MOUNTAIN'S EDGE
PLAN AND PROFILE
EL PASO COUNTY, CO

Road Plan and Profiles_V1.pdf Markup Summary

PCD File No. SF-20-001

Sheet: 2 of 3

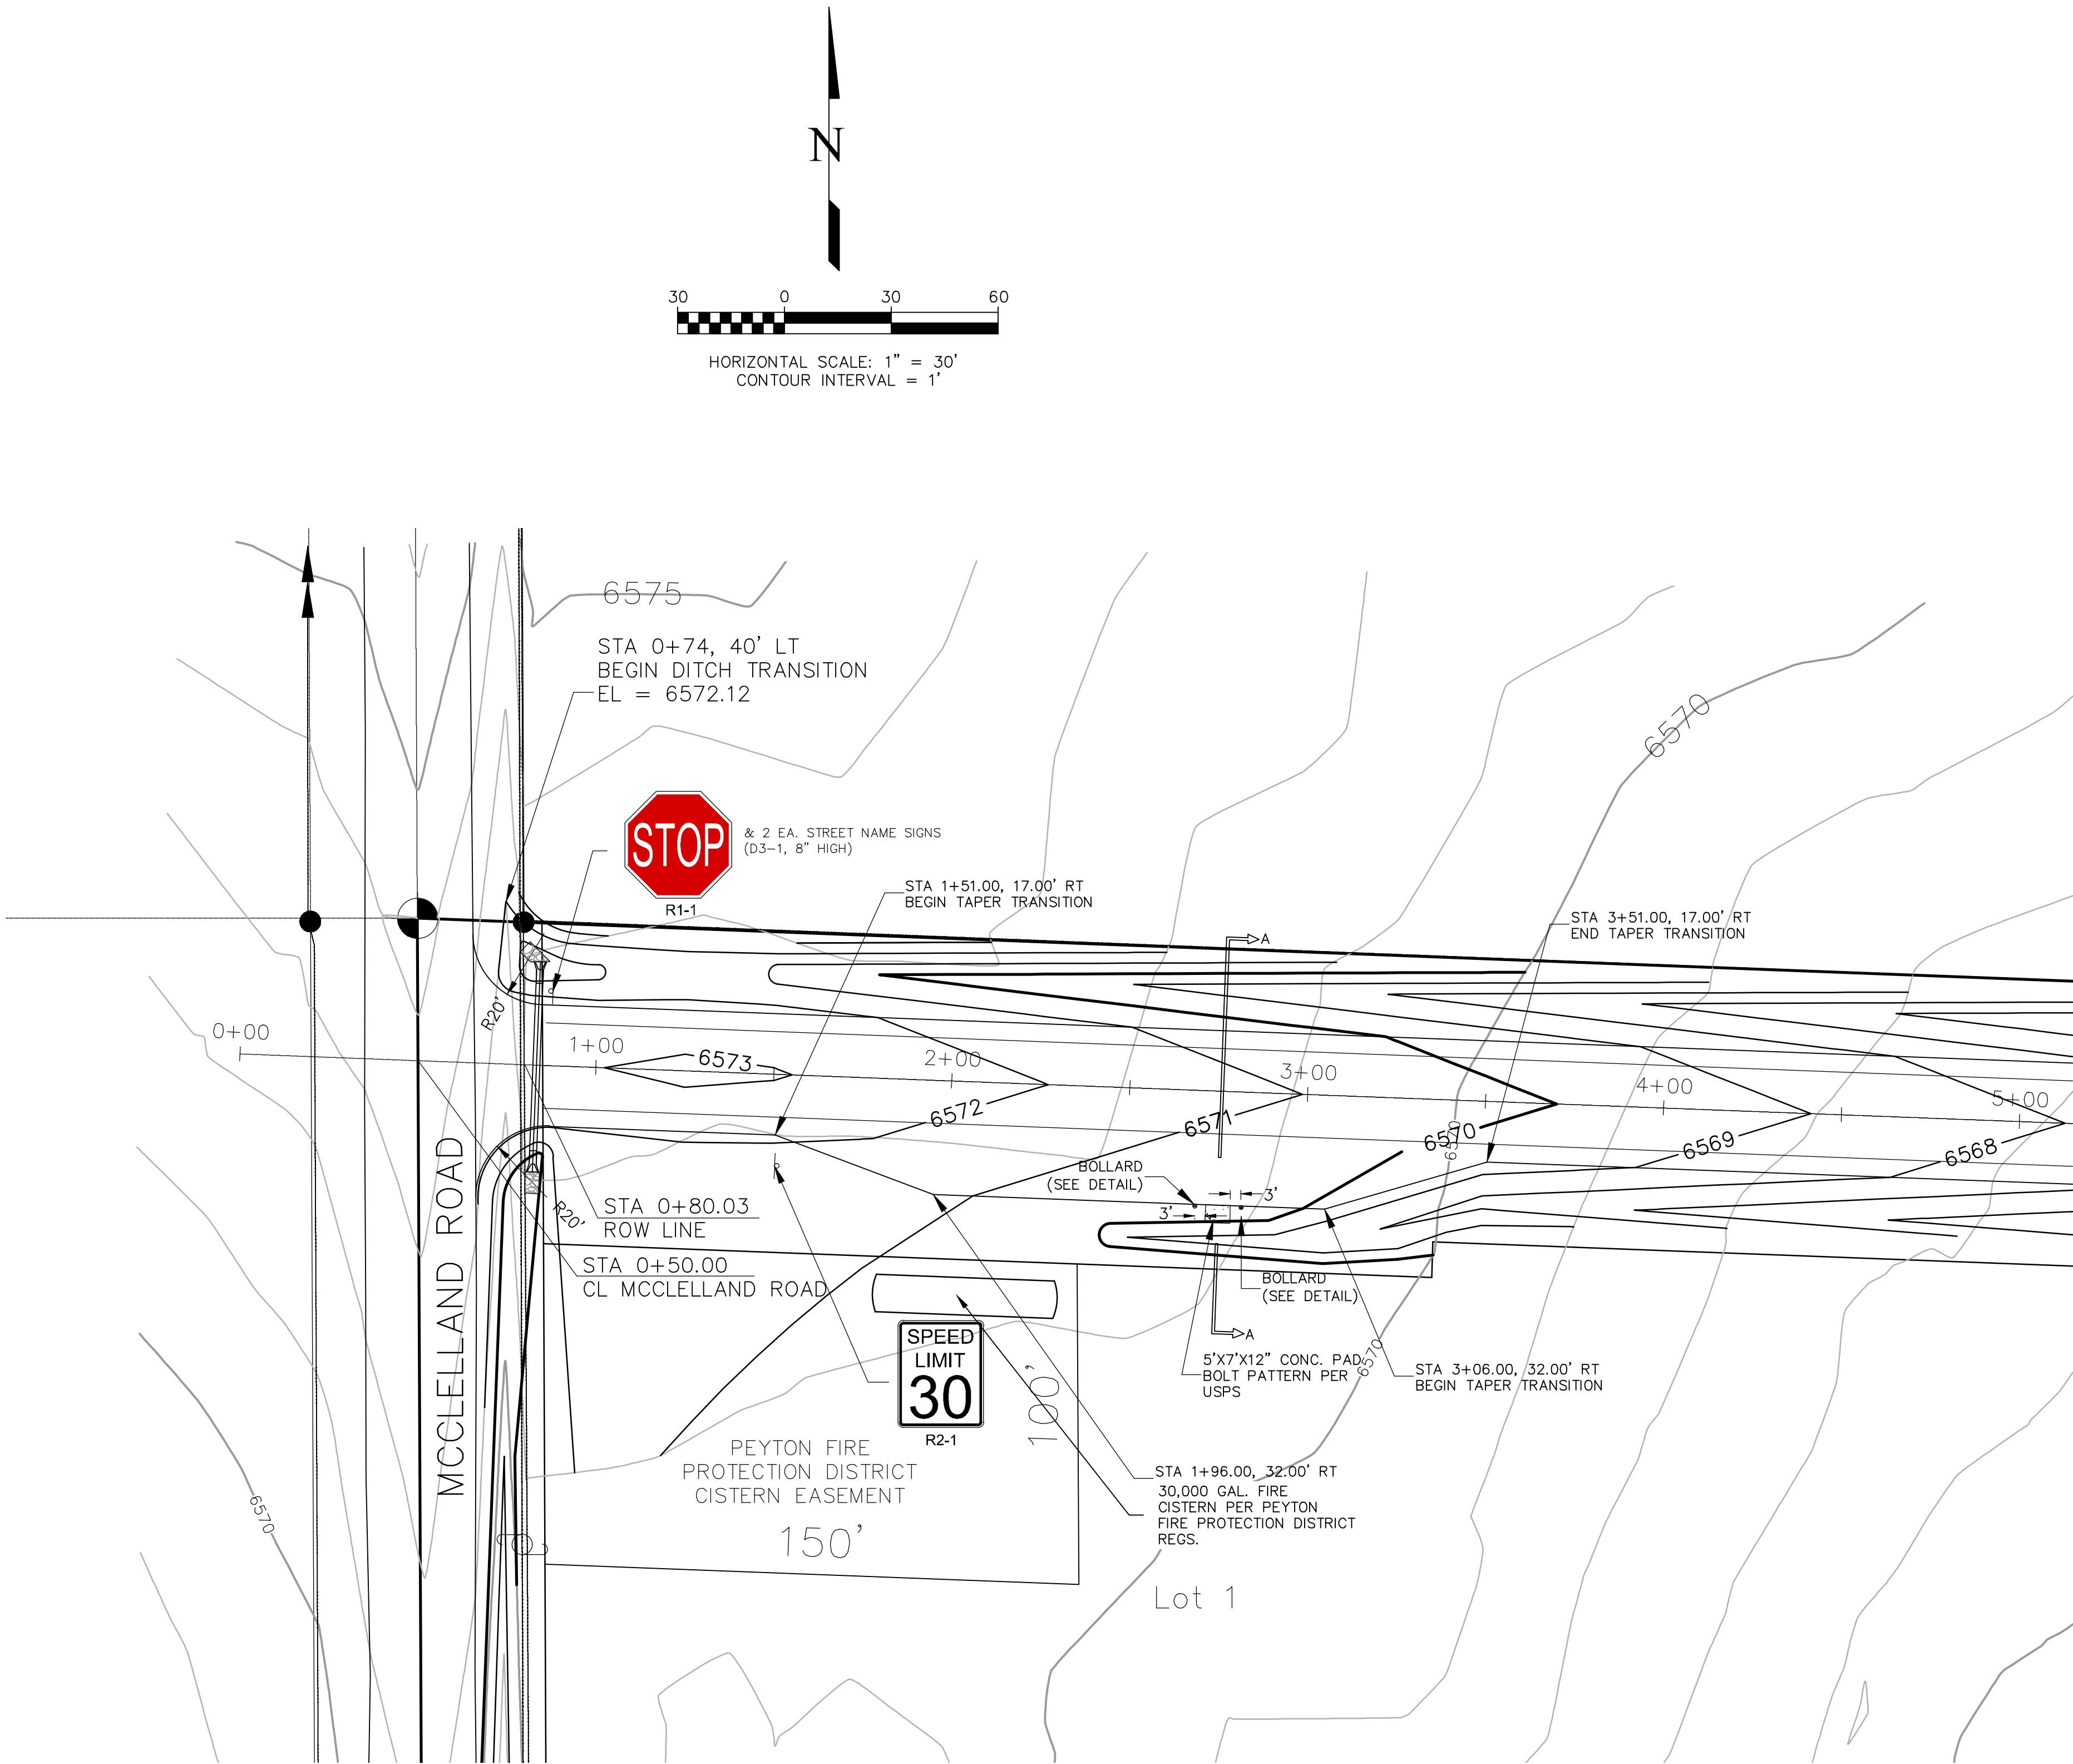
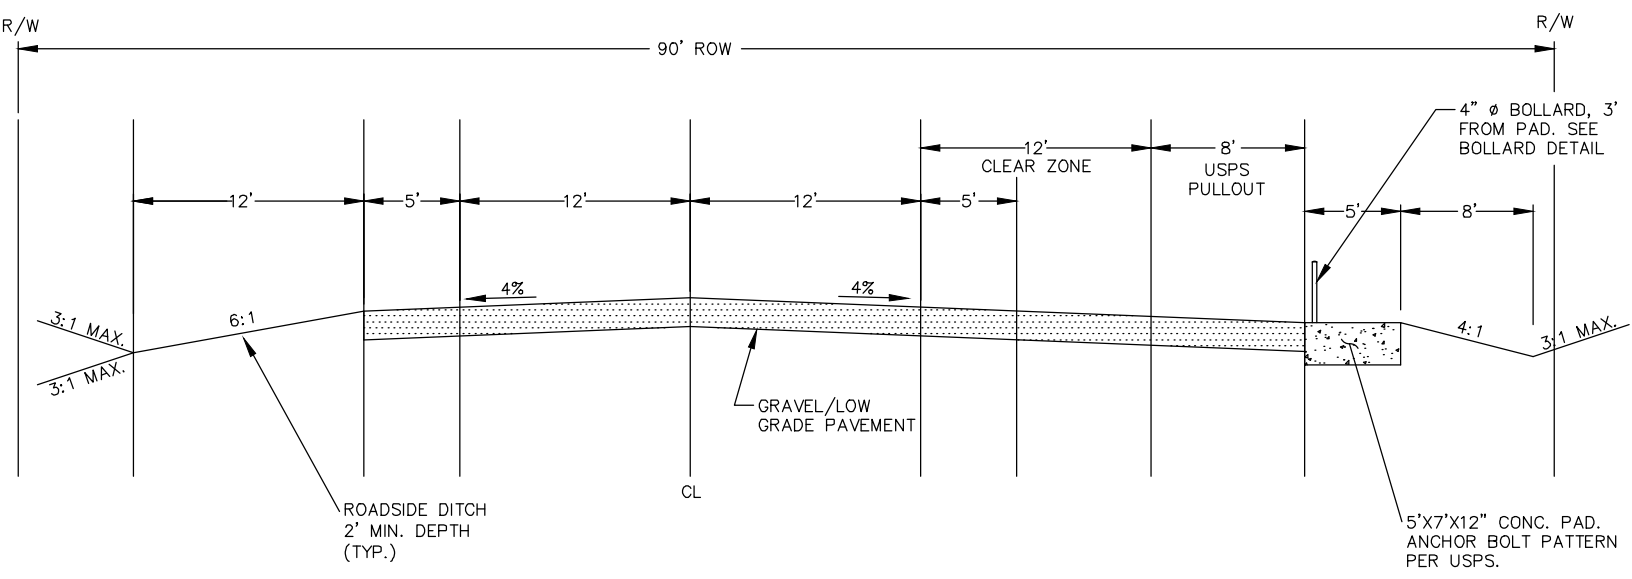
Update proposed contour tie-in to existing. Tie-in as shown is incorrect.
Examples: Contours between the culvert ends must tie into the existing contours west of the ditch flowline. Contour 6571 downstream of the culvert should not cross the proposed flowline.

Show the edge of gravel

Fix the transition. As shown, the northern ditch bank of Farmhouse Ct is impeding flow into the culvert.

Show sign post and identify street name signs to be installed with the stop sign.

Revise road profile or culvert invert to meet minimum 2 ft cover from finished road surface per ECM 4.3.6.A.3

Provide a plan & profile for this culvert

Provide curve data for the cul-de-sac.

update contours around the culvert. Ditch side slope shown is steeper than 3:1.

Provide curve data

Label vertical scale for profile
